**From:** Plant, Tom - Communities <Tom.Plant@Oxfordshire.gov.uk>  
**Sent:** 21 January 2020 18:23  
**To:** Bob Neville  
**Cc:** DC Support; Cllr George Reynolds  
**Subject:** 19-02700-F - Mawles Farm Main Street Sibford Gower OX15 5RW

**Planning application:** 19/02700/F  
**Location:** Mawles Farm Main Street Sibford Gower OX15 5RW  
**Description:** Conversion of existing stone/brick barns to 1 no. dwelling and conversion of existing steel pole barn to 1 no. dwelling. Associated works including landscaping and new access  
**Type:** Full Development  
**Case Officer:** Bob Neville

**01** Main Street Elevation As Existing  
1:200

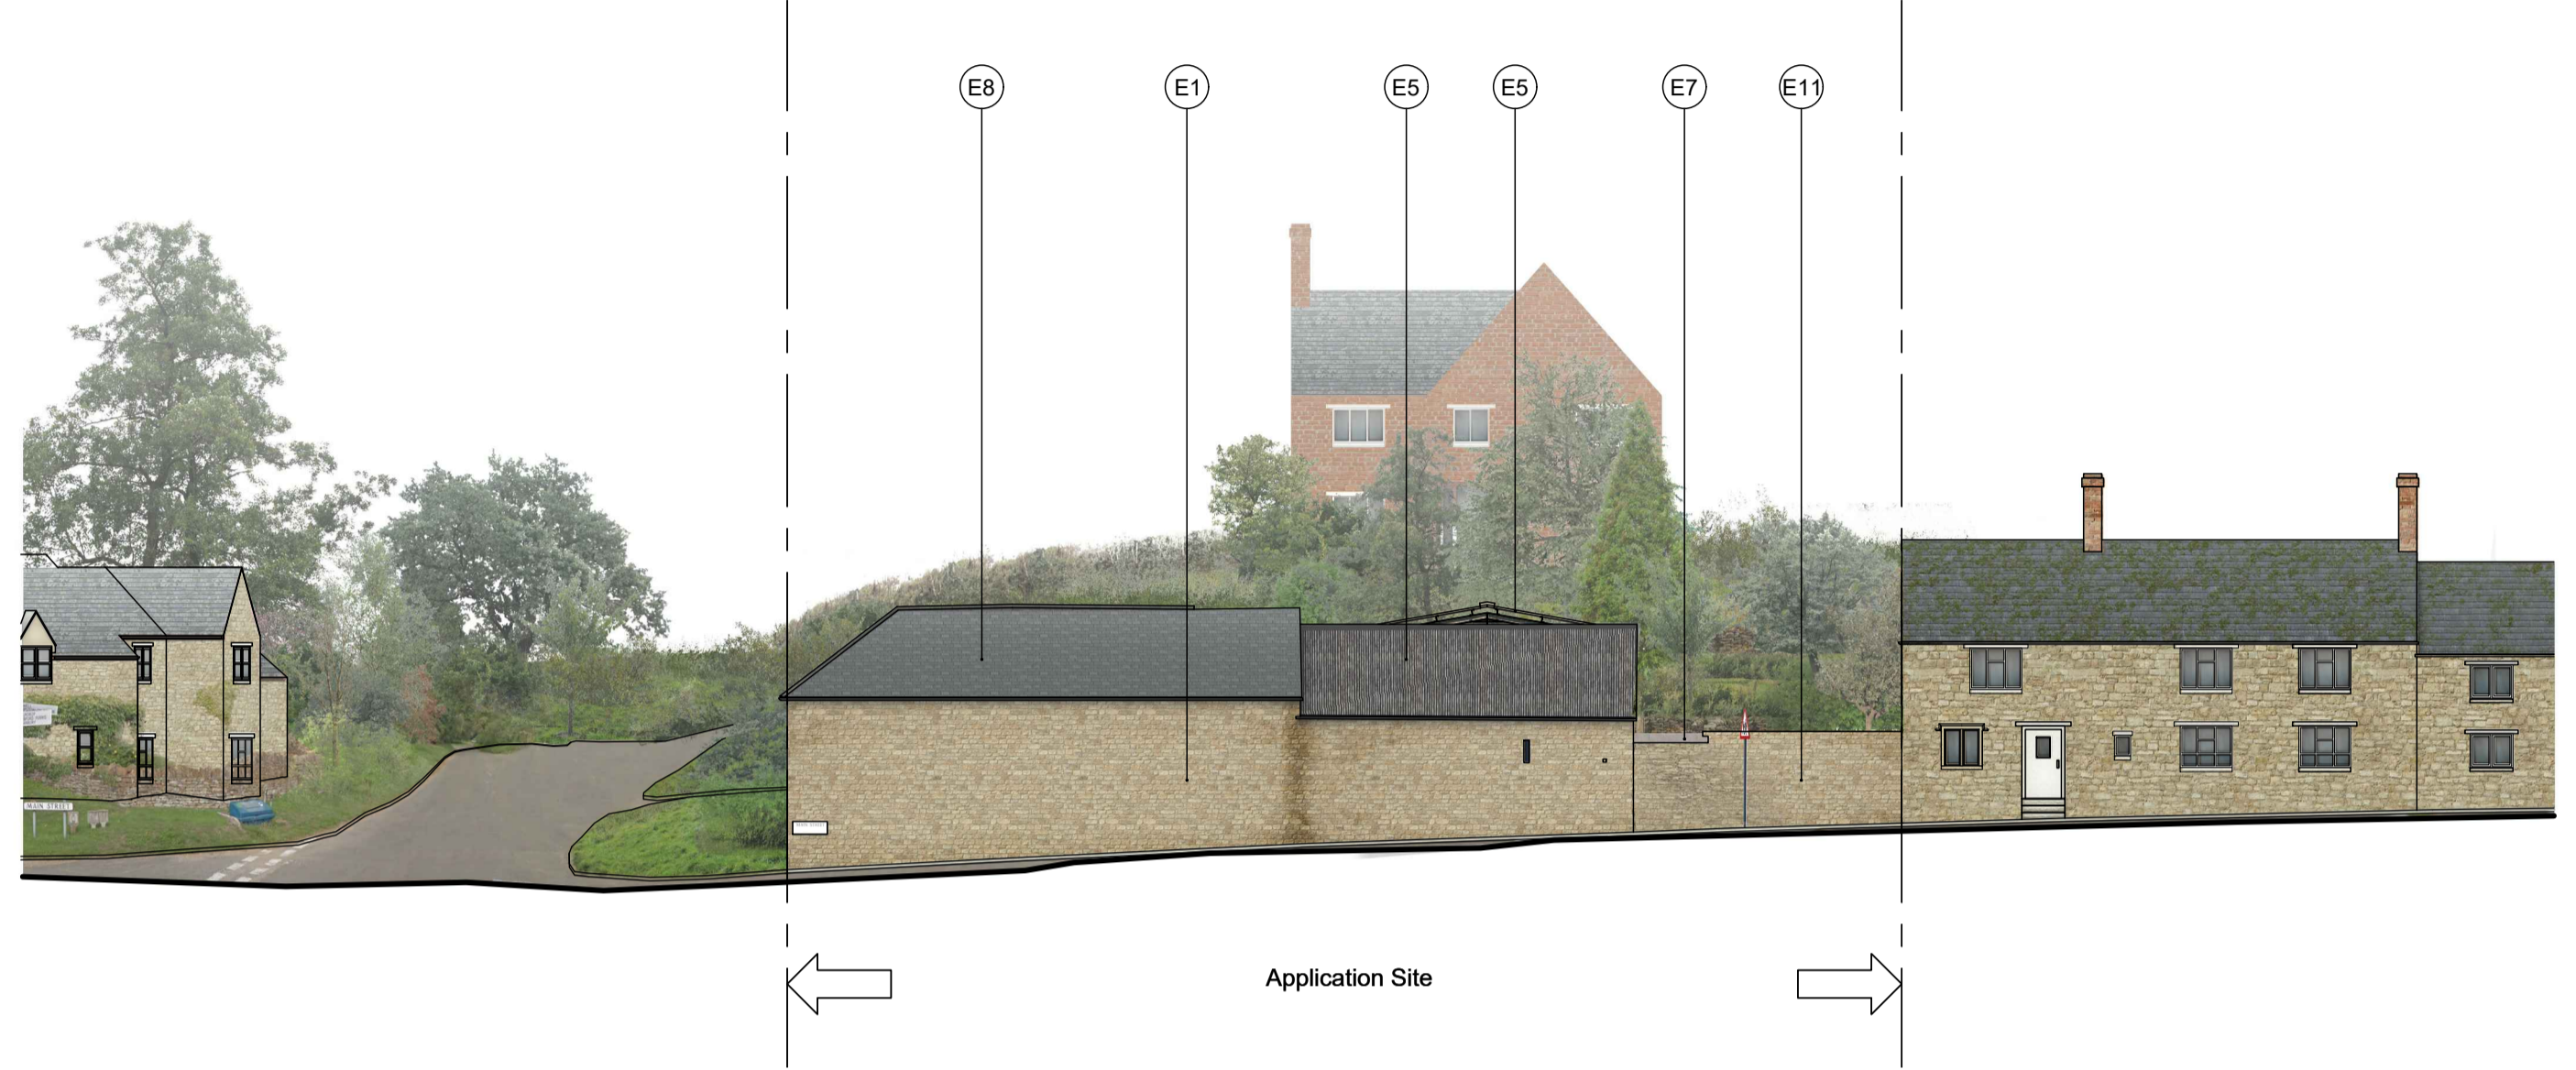
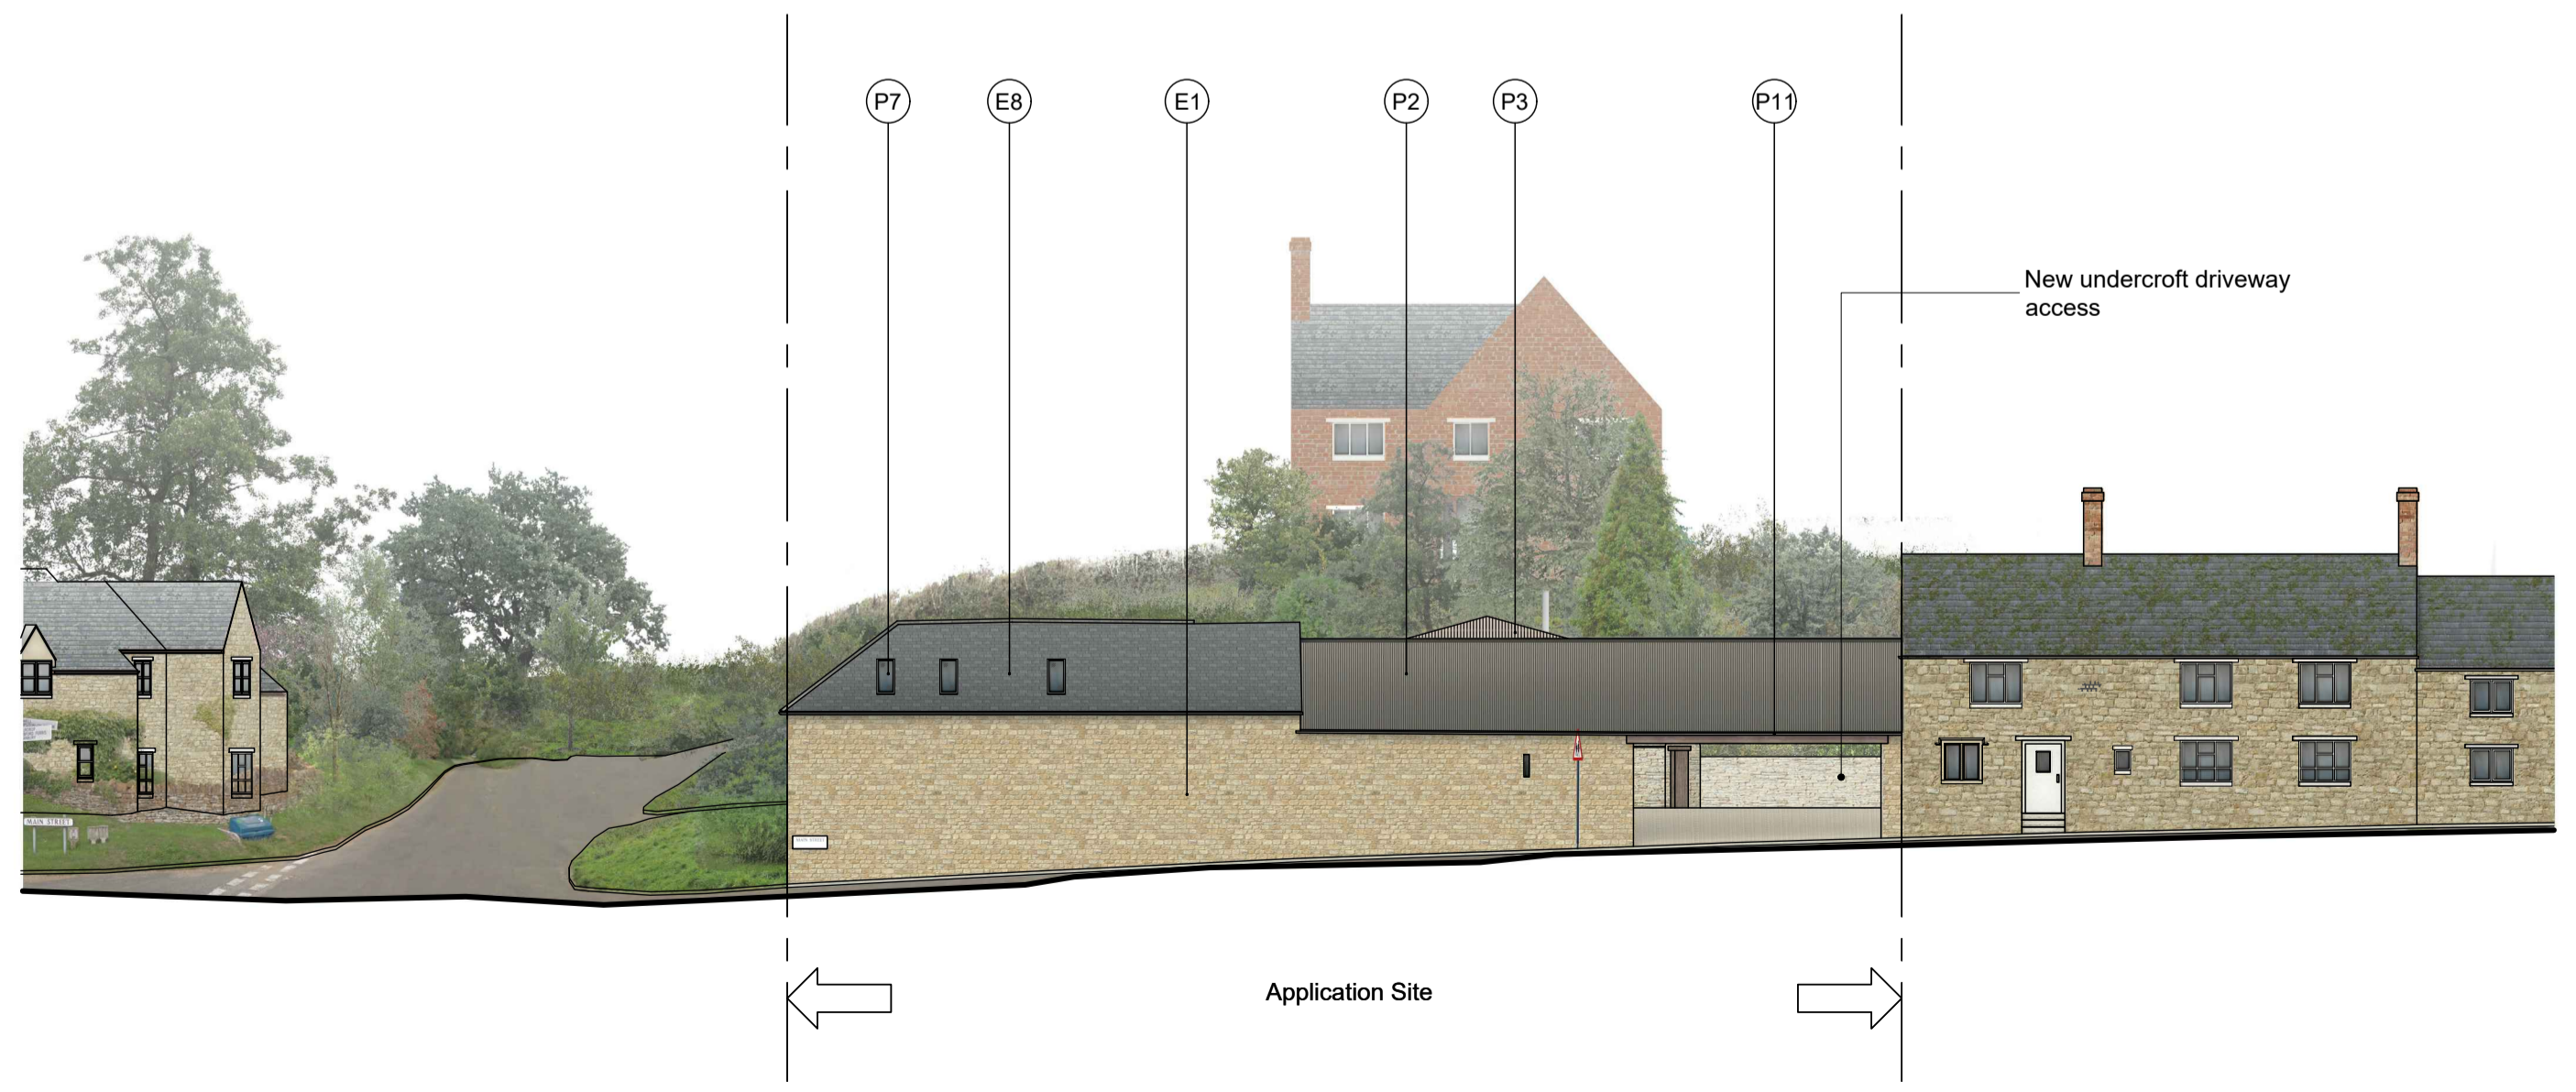
It is proposed to remove approximately 8m's of wall between the gable end of the barn and opposite the dwelling's cable end (dwelling currently marketed for sale). Whilst 8m's of wall is proposed to be removed, the actual access proposed is approximately half the width. The remaining gaps therefore provide vehicles egressing inter-visibility for pedestrians who may be on the footway. This inter-visibility is required as egressing vehicle will need to push the nose of the vehicle out onto the footway in order to safely egress the site. Paras 3.1 - 3.6 of the Access Appraisal cover this in detail and take into account the school warning sign which will need to be relocated in order for this access to be viable. I, as result, see no reason to disagree with this appraisal for a new access out onto Main Street based upon the level of development that is proposed, therefore I have no objection to this access.
